From: Laura Mills
Sent: 11 September 2026 14:40
To: [REDACTED]
Subject: F/40/26/PL Environment Agency, Ford Depot, Station Road

F/40/26/PL
Environment Agency, Ford Depot, Station Road

Drawing Title:
EXISTING LOCATION PLAN

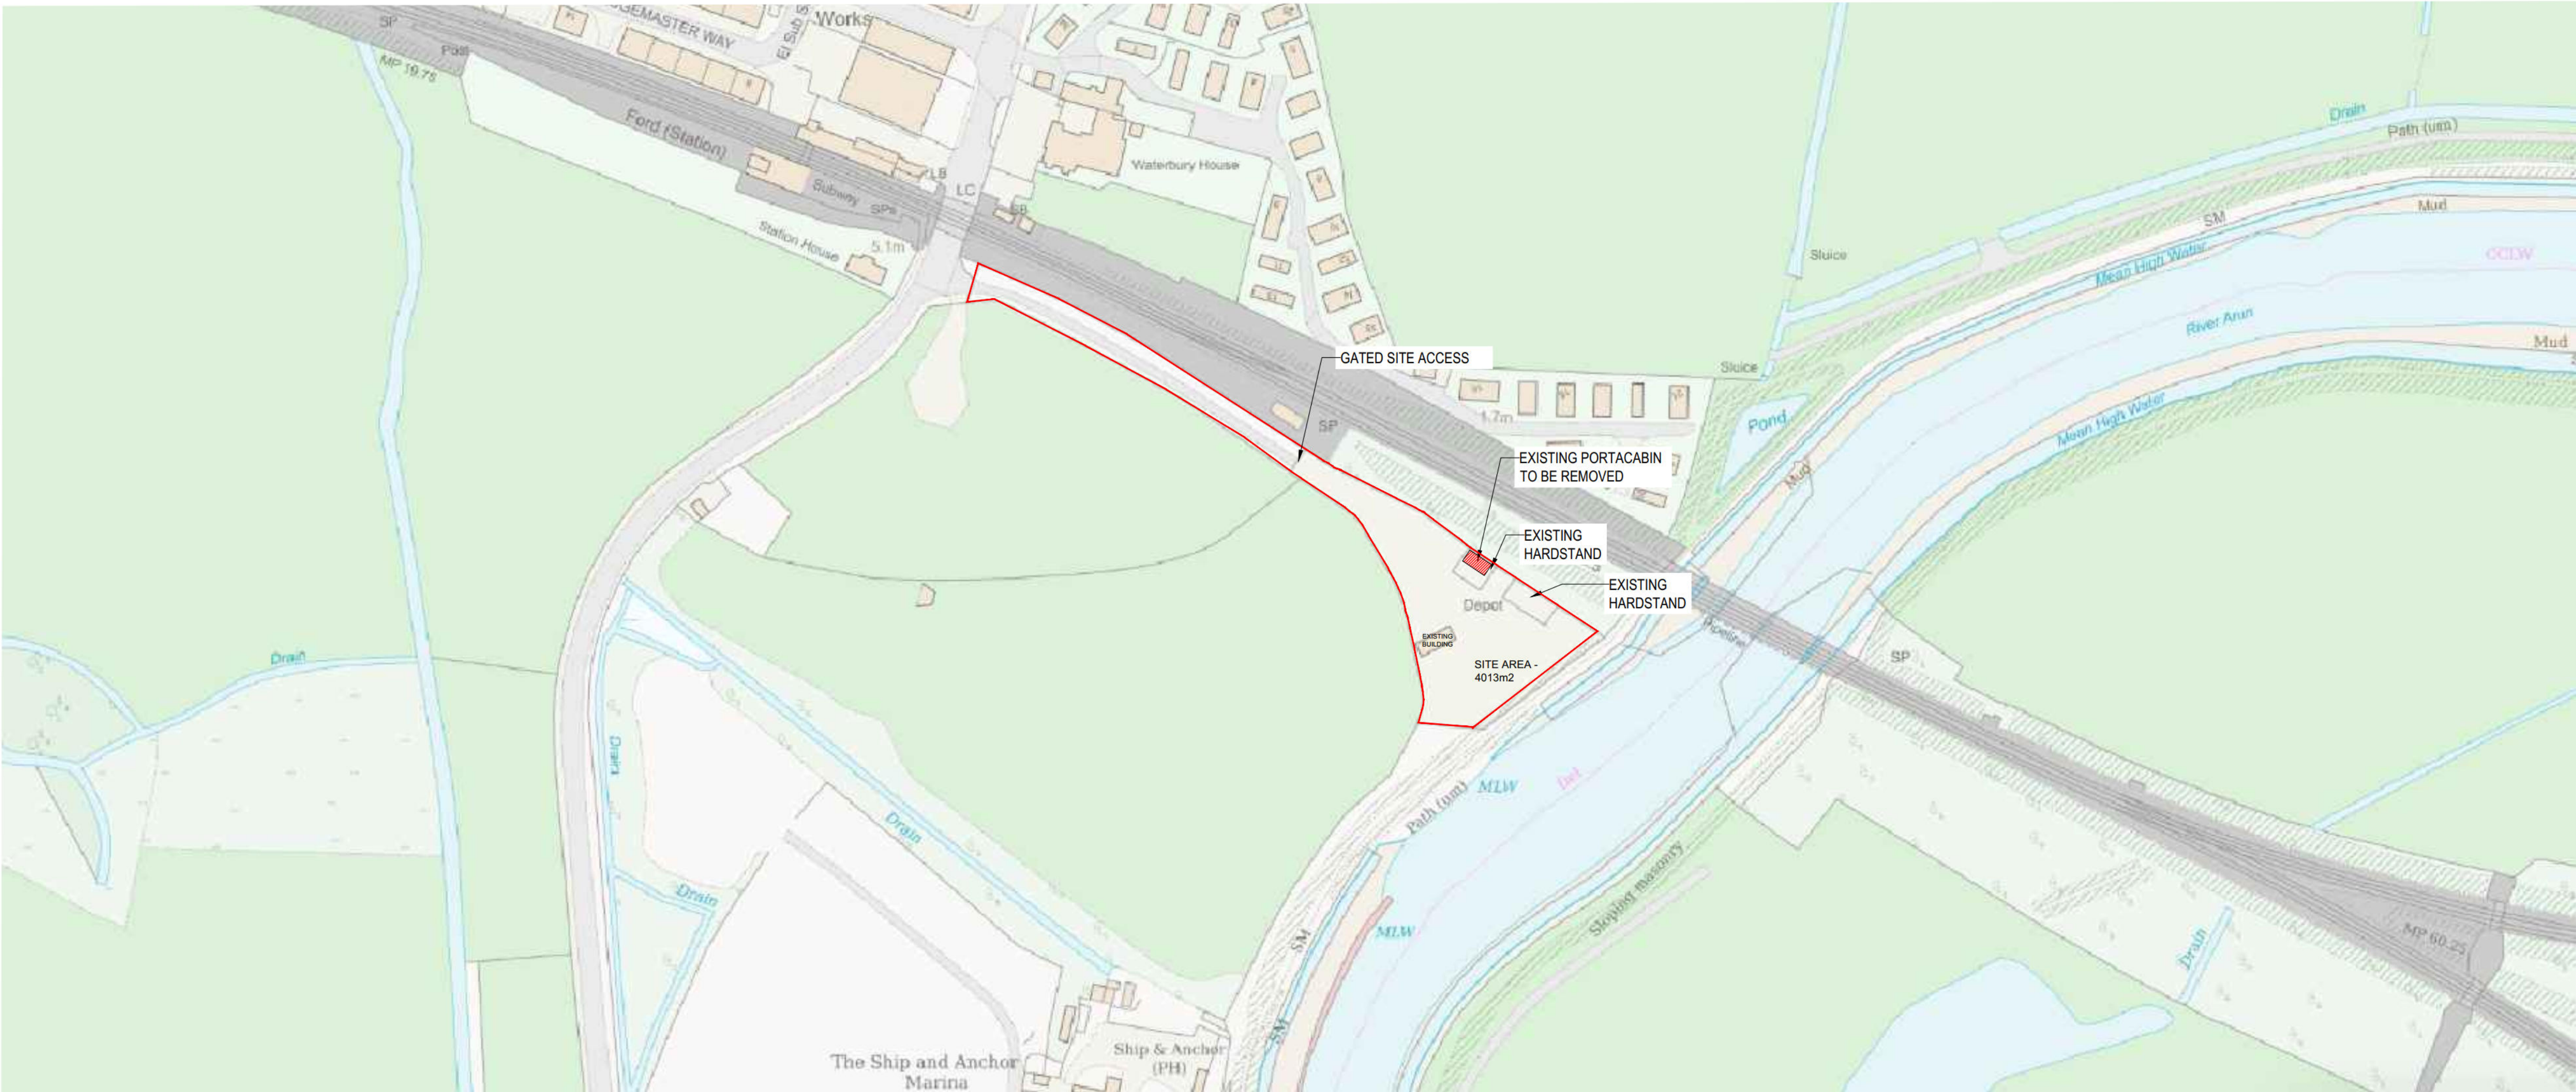
LOCATION PLAN (Drg no. 0001)

The plan does not indicate the scale, please amend.
